PORTLAND MAINE

June 3, 2008

RE: 113 Deepwood Drive – 397 C017 – R2 – expand rear deck – permit # 08-0601

NEW DECK

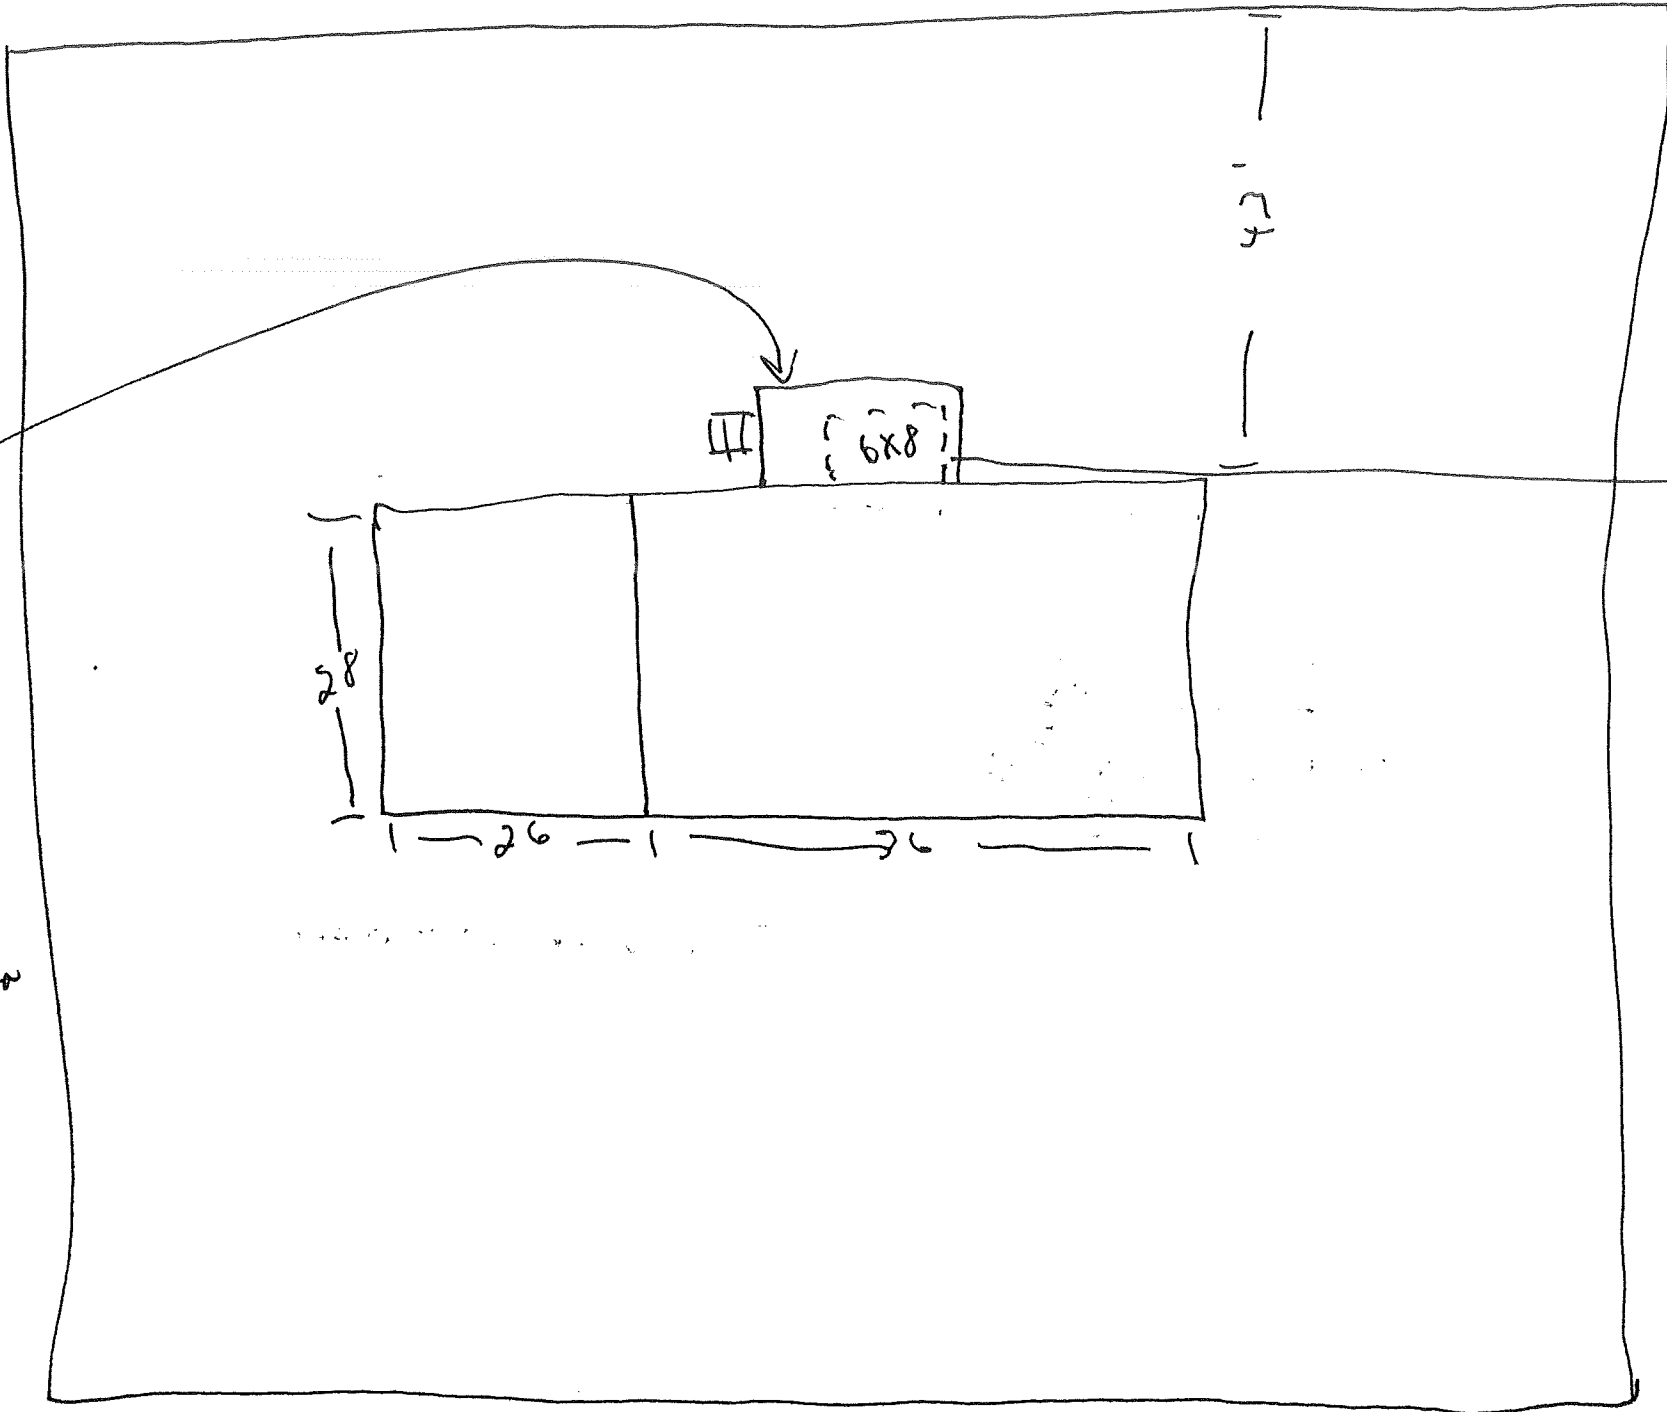
I am in receipt of your application to put a larger rear deck on the back of the house at 113 Deepwood Drive. Your house is located in the R-2 residential zone. Section 14-80(e) of the ordinance states that the maximum lot coverage in the R2 zone is twenty percent of the lot area. The size of your lot is ten thousand square feet. Twenty percent of that is two thousand square feet. The footprint of the existing structure including the existing six by eight foot deck is 1,928 square feet. The proposed 12 foot by 24 deck would add 240 square feet to the footprint for a total of 2,168 square feet. This is 168 square feet more than the allowable maximum lot coverage. Since your proposed deck expansion is over the maximum allowable lot coverage, I must deny your application.
